Hello,
Thankyou very much for the consultations. The **Arun Conservation Area Advisory Panel** wish the following comments to be taken into consideration in the determination of the applications:

FG/35/26/HH and FG/36/26/L - Home Farm House, 63 Ferringham Lane, Ferring

Rev	Date	By	Description
A	18/3/2026	A.K	General Arrangement

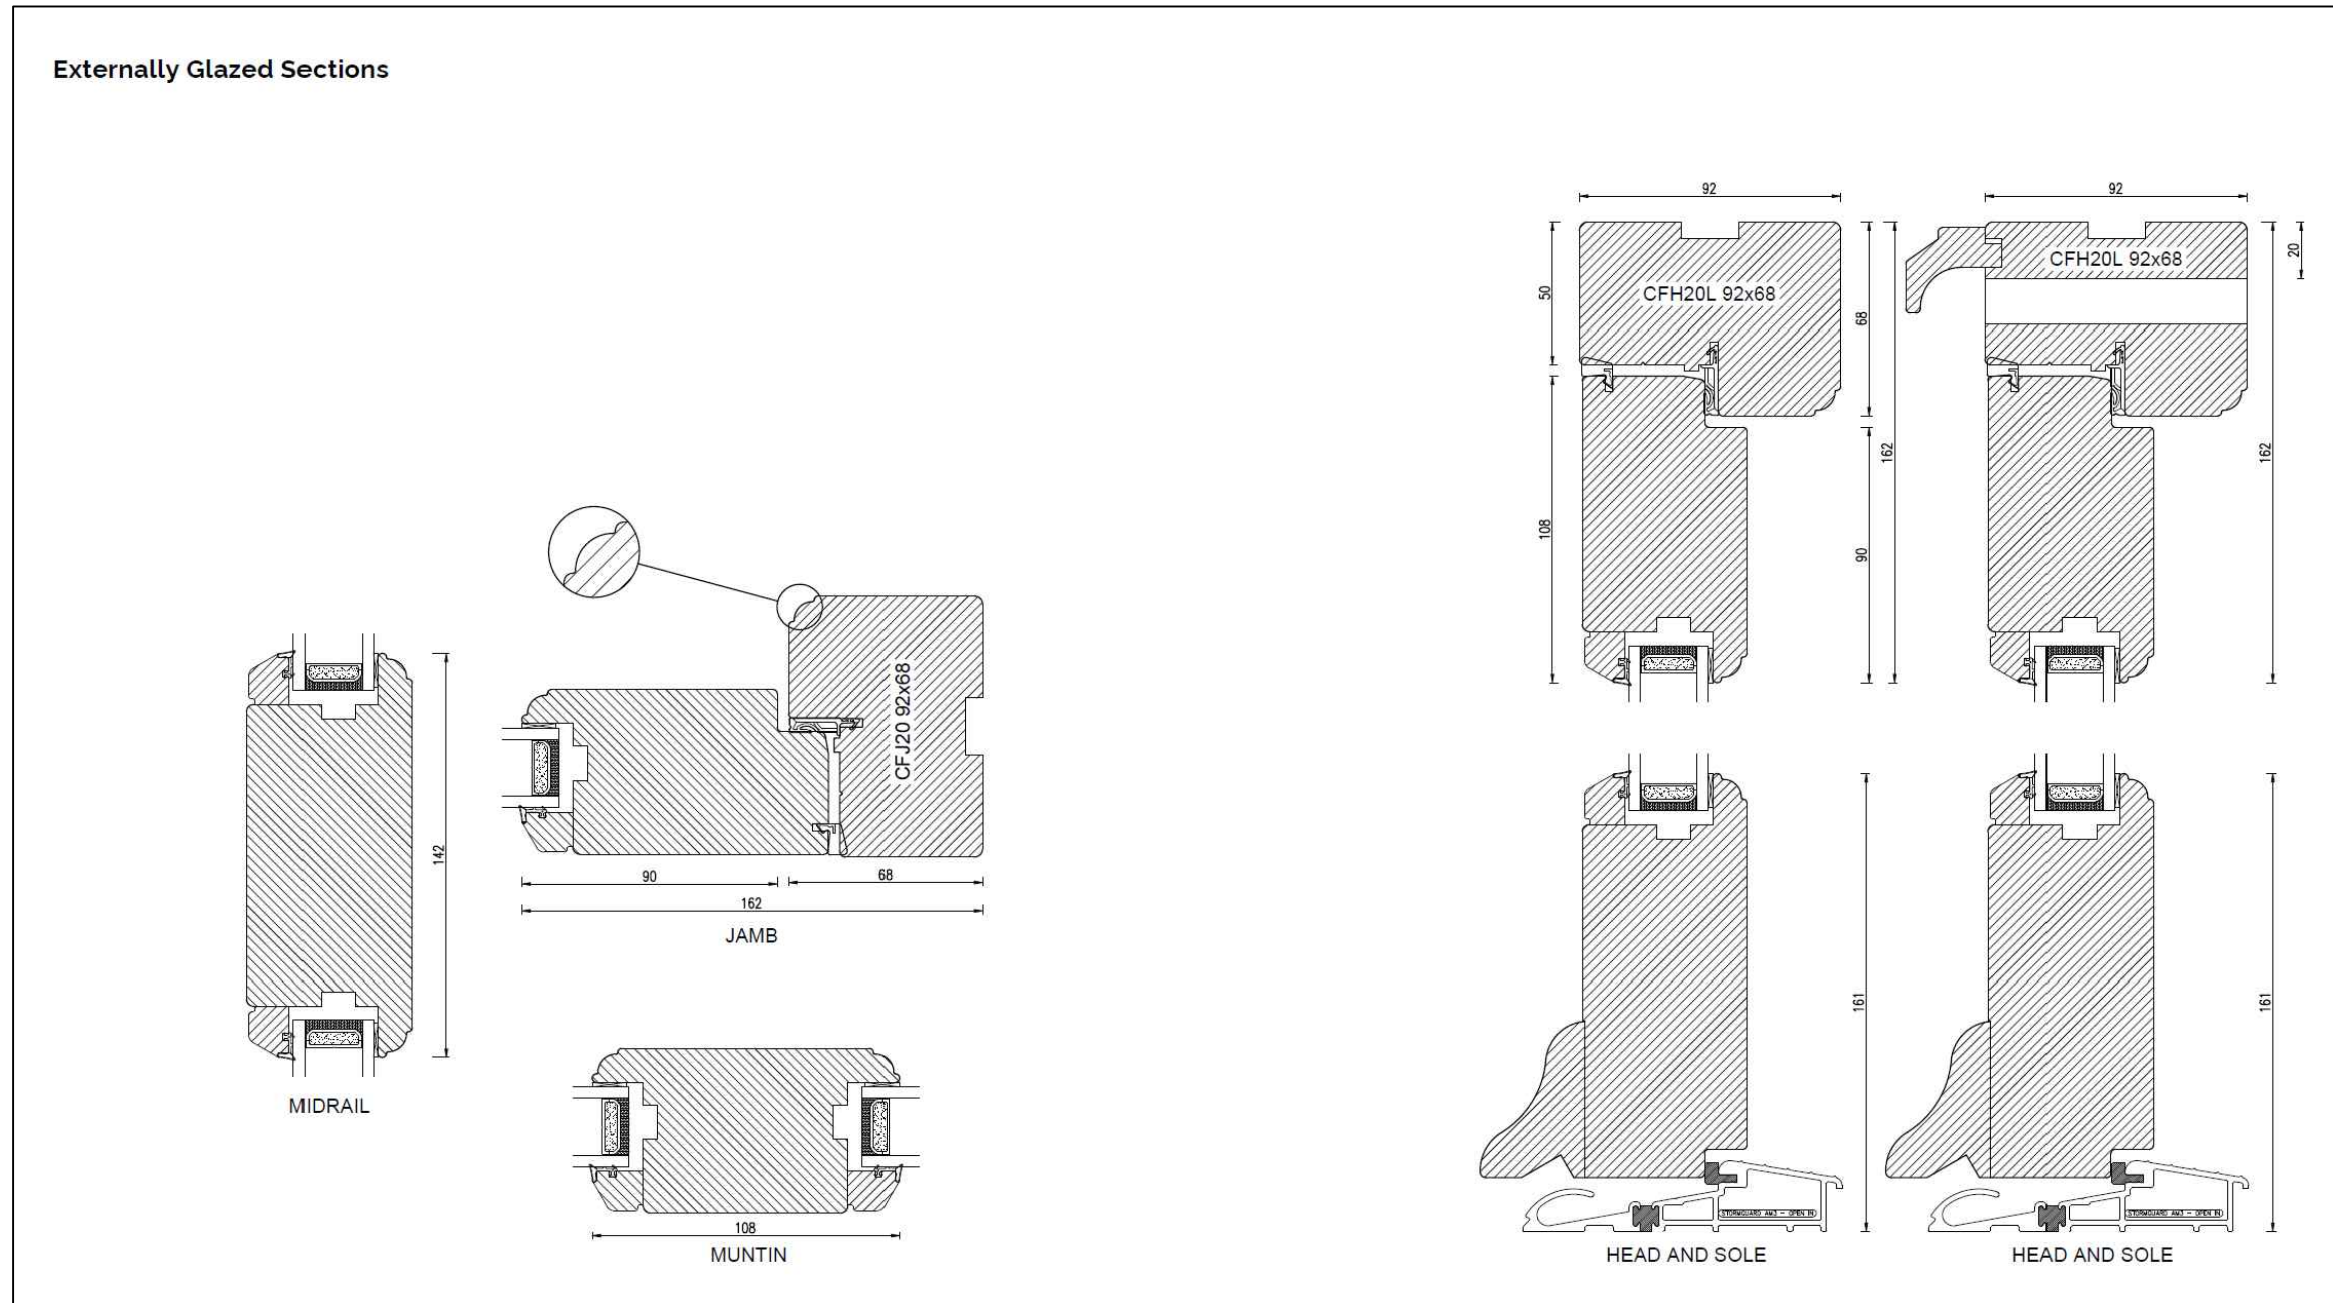
The age, design and architectural merit of the building indicate that its windows are an essential part of its heritage significance.

The advice of Historic England does not appear to have been followed in this instance. There is no comprehensive condition report on the existing windows to indicate whether or not they can be reasonably repaired. The double glazing units are too thick and the use of false glazing bars is simply inappropriate in an historic building.

Historic England provide ample advice on how to improve the thermal efficiency of historic windows, useful adaptations such as secondary glazing, and if they need to be replaced the best methods of doing so.
